This design and access statement has been prepared in support of a Revised Planning Application for the extensions and alterations of the existing block of flats with the following principal elements:

The application site is within the West Drayton Green Conservation Area, the existing building is not listed.

The recent planning application 8878/APP/2019/1909 was refused on 4 September 2019 for the following reason:

DRAWING
DESIGN & ACCESS STATEMENT

DRAWING
PROPOSED GROUND FLOOR

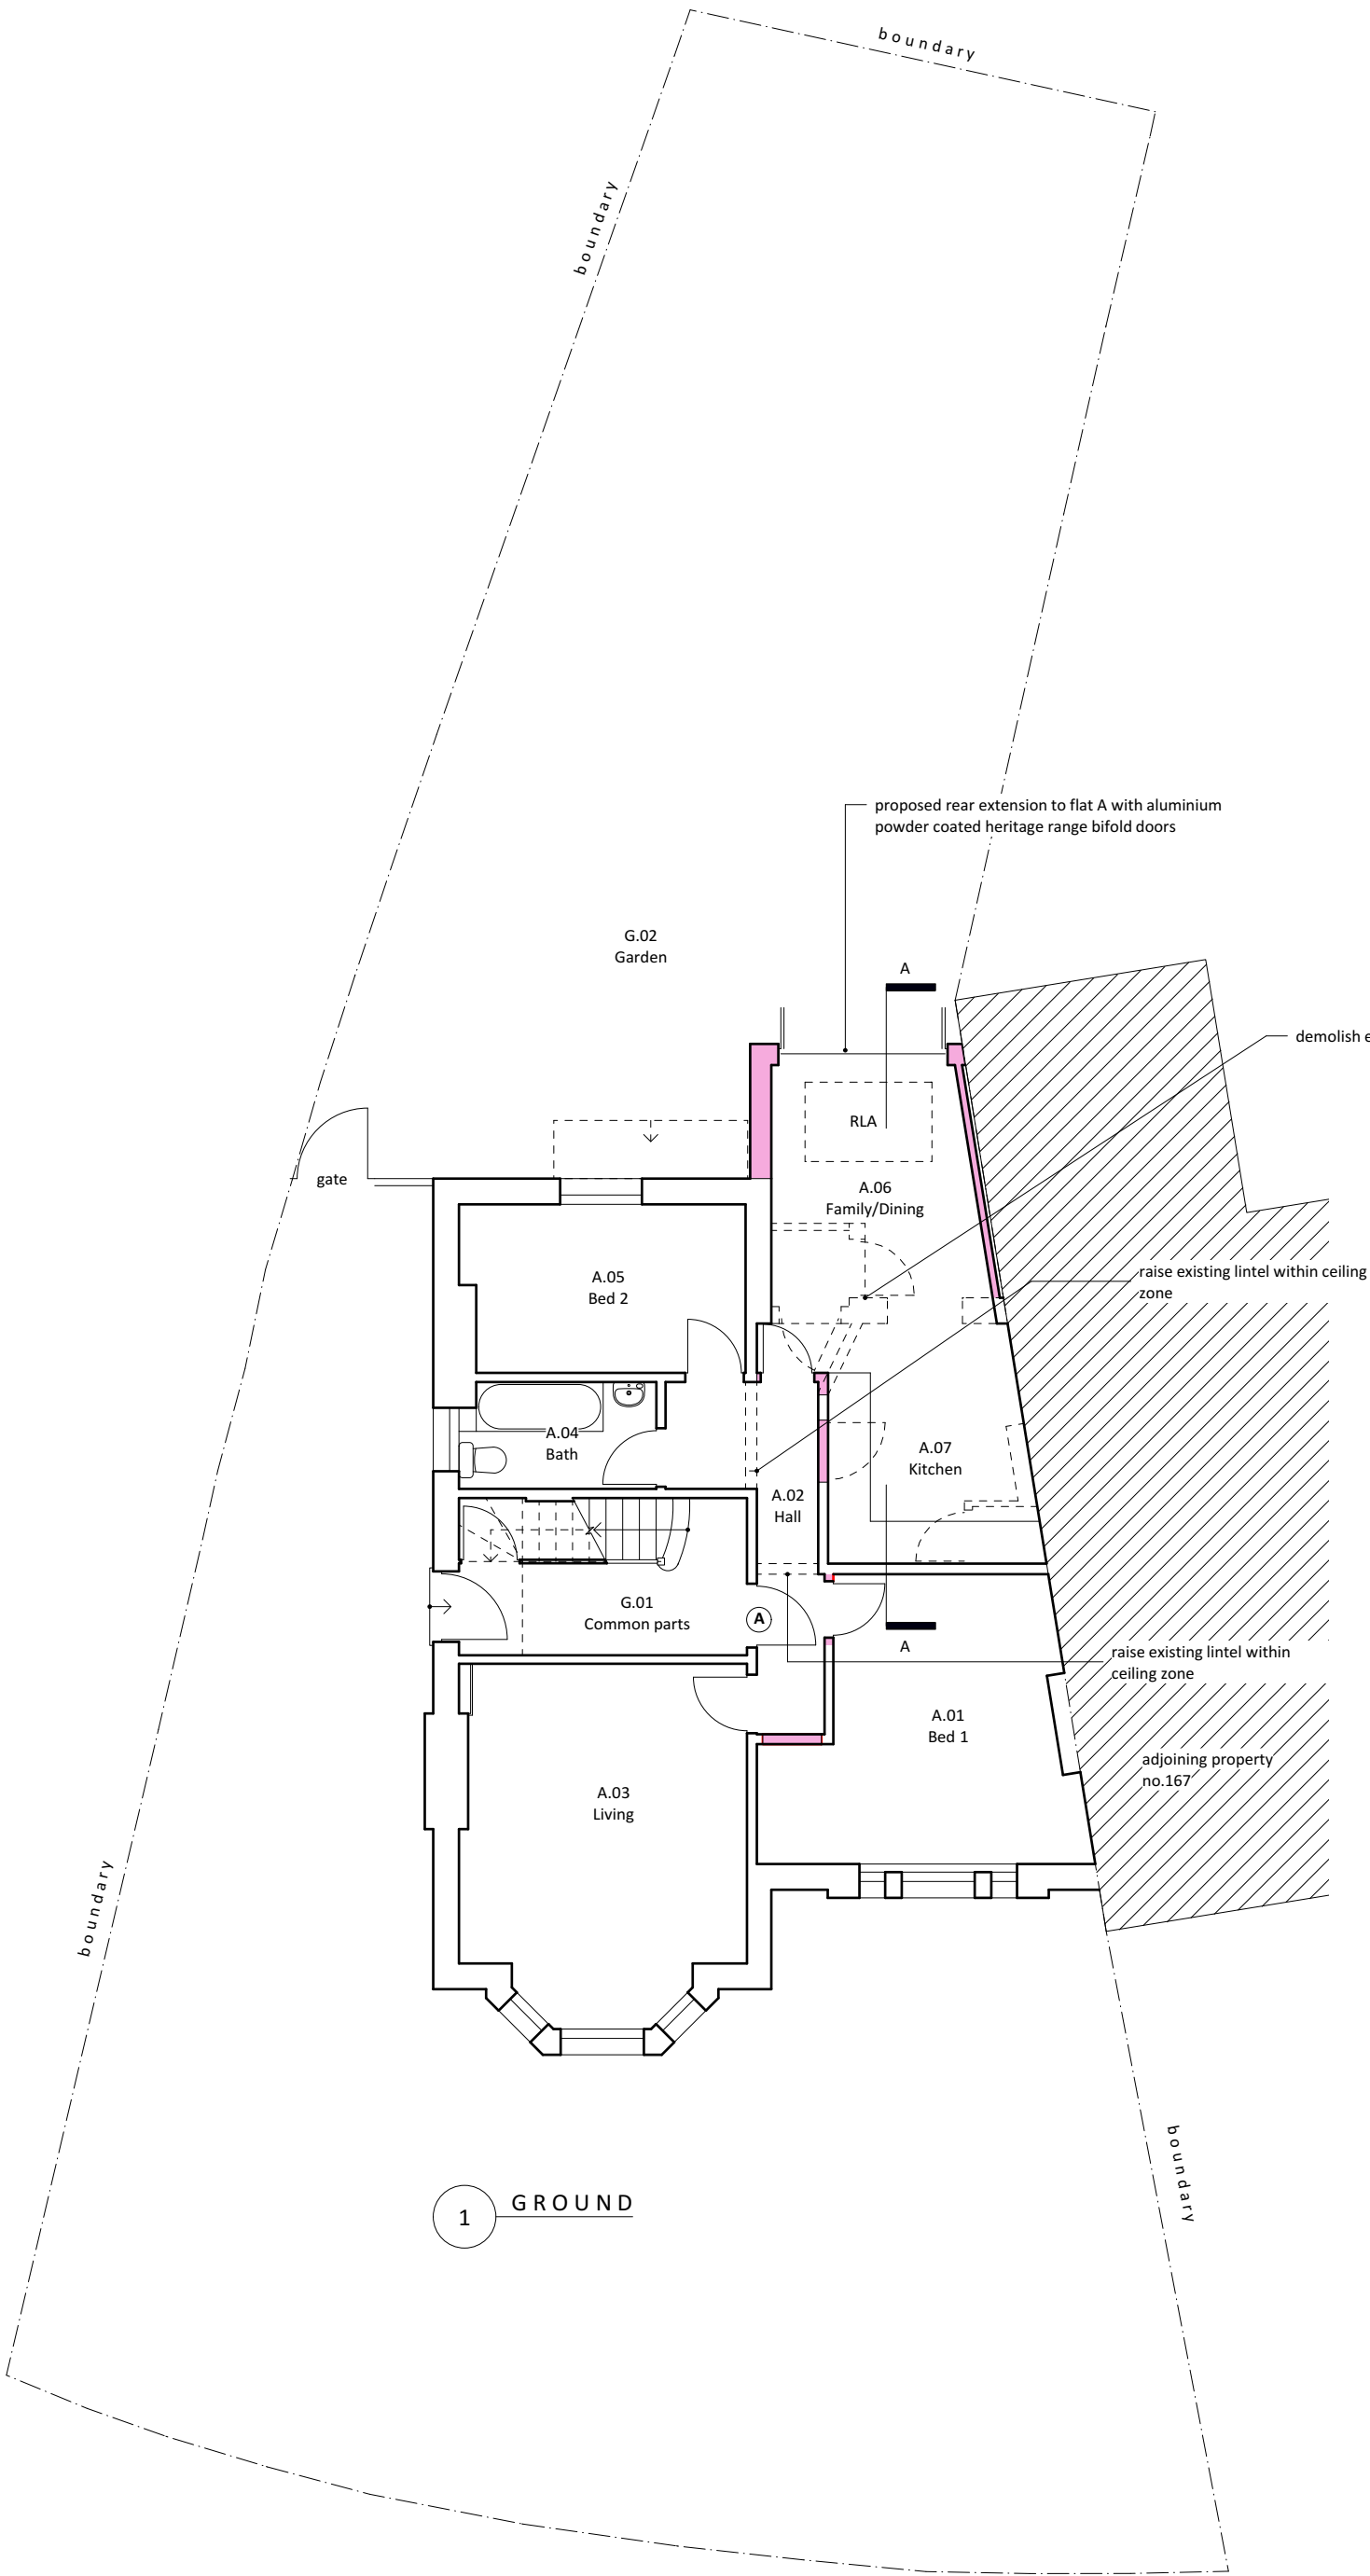
Officer's Comment 4:
'The ground floor part of the extension, on its own, would likely be acceptable.'

The external fenestration and design remains unchanged on the ground floor extension.

4 ROOF

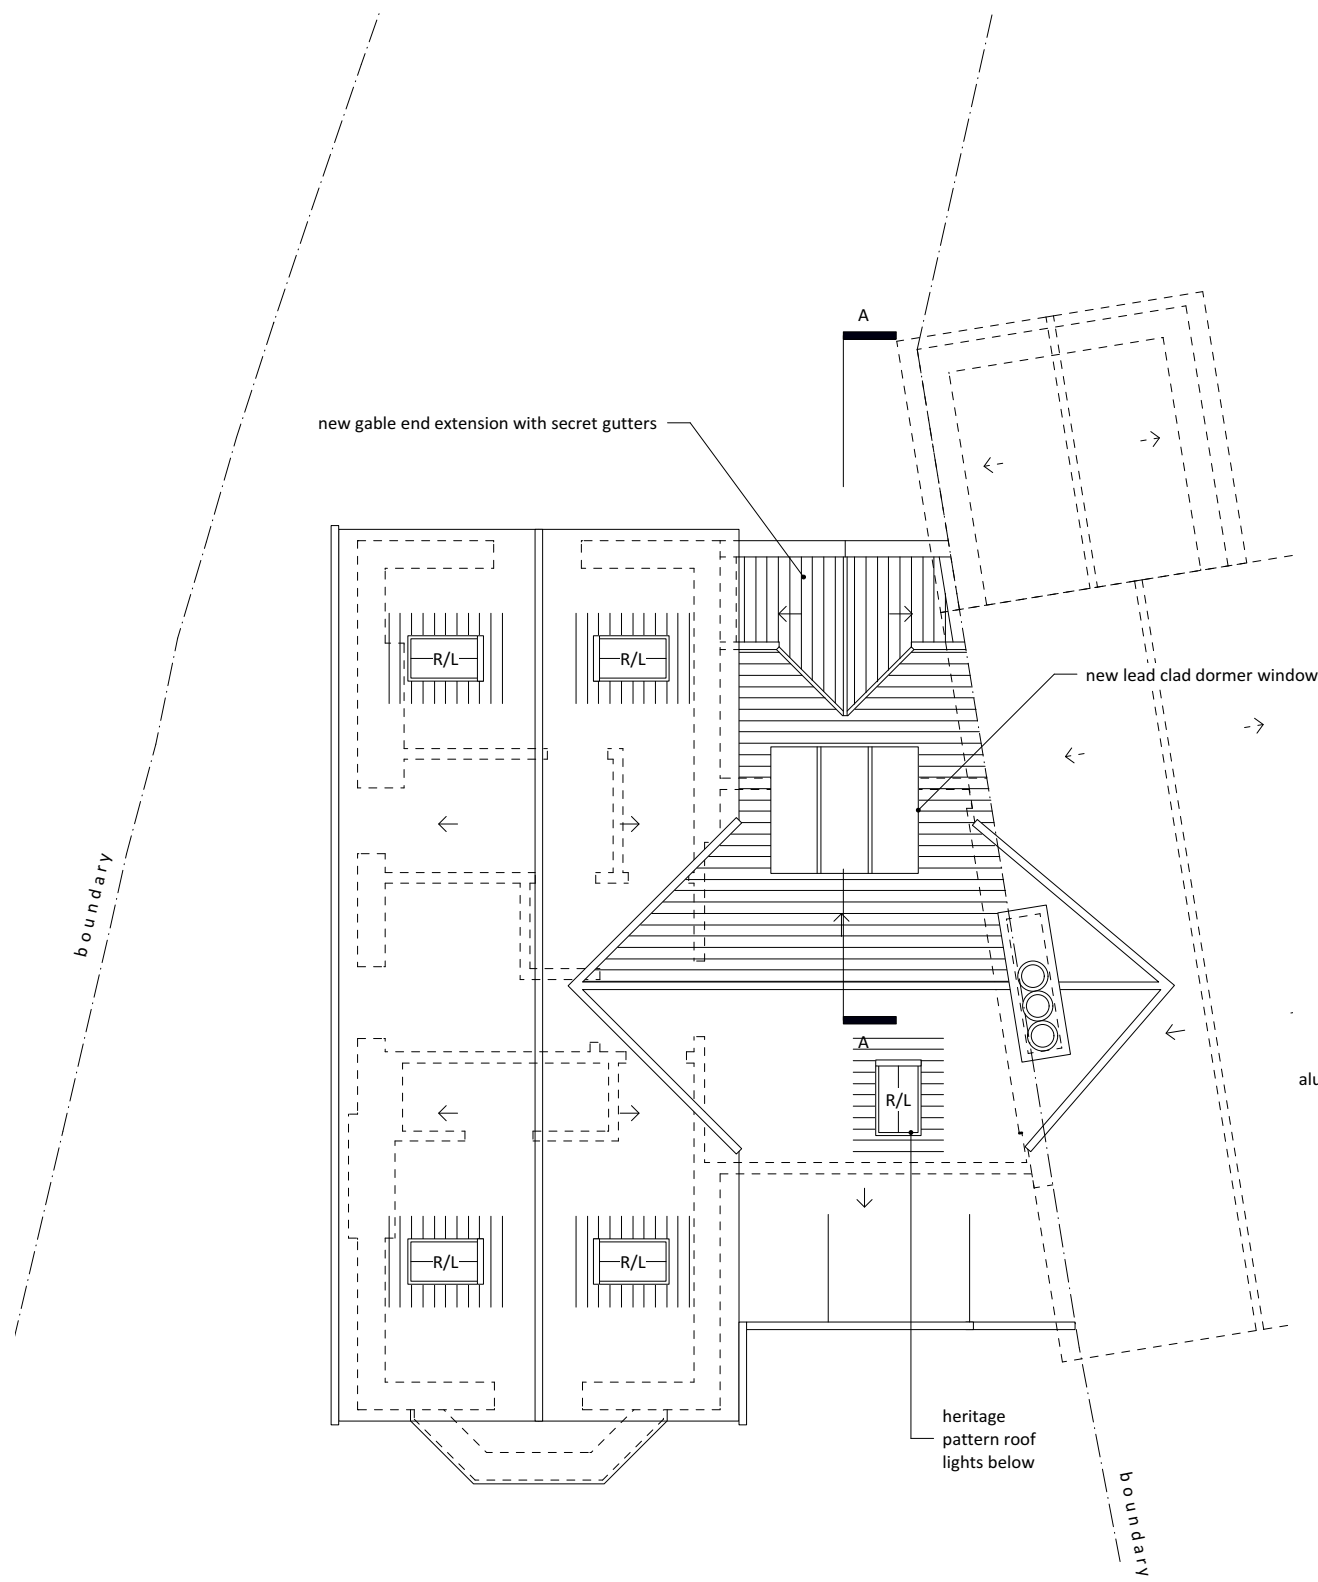
Officer's Comment 3:
'The proposed roof lights to the front elevation are not best positioned on the elevation and are uncharacteristic of the area. It would be preferable to avoid them.'

- The number of rooflights on the front roof slope has been reduced to one , which has been centrally positioned on the bay window and sash window below. The rooflight is a conservation pattern specification, it is difficult to avoid rooflights on the front slope as it dramatically increases the light within the living area.

- Four number roof lights have been introduced to the north and south (side) roof slopes so that they are not visible on the front elevation. Again the rooflights are of conservation pattern specification.

5 SECTION A - A

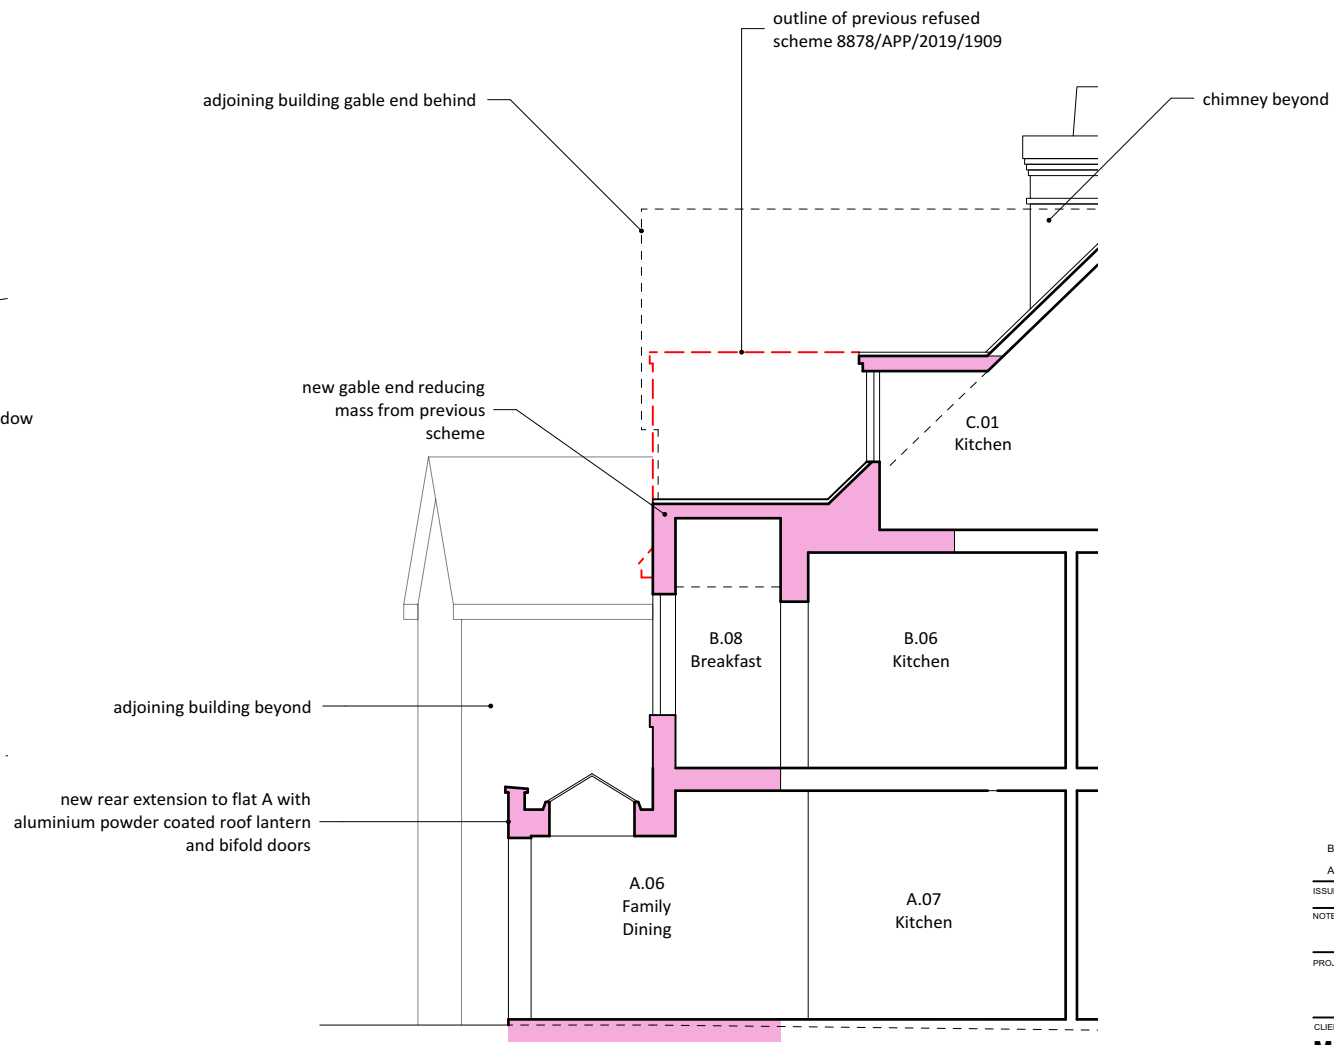
Officer's Comment 2:
'It is felt that the proposed 3-storey extension would fail to respect the form of the original property or the balance of the group of properties and would significantly alter the character of the roofscape. This is due largely to the loss of the stepped form of the building, the loss of balance to the group, and the extended dormer which is not typical of the local roofscape. The proposals, due to the wedge shaped plot and next door's 2- storey extension, also create a crowded appearance at the rear. The use of Juliet balconies for windows at first and second floor levels, are also unacceptable being uncharacteristic of the original property or the neighbouring properties.'

- Section A-A shows the stepped form re-introduced with the current design.
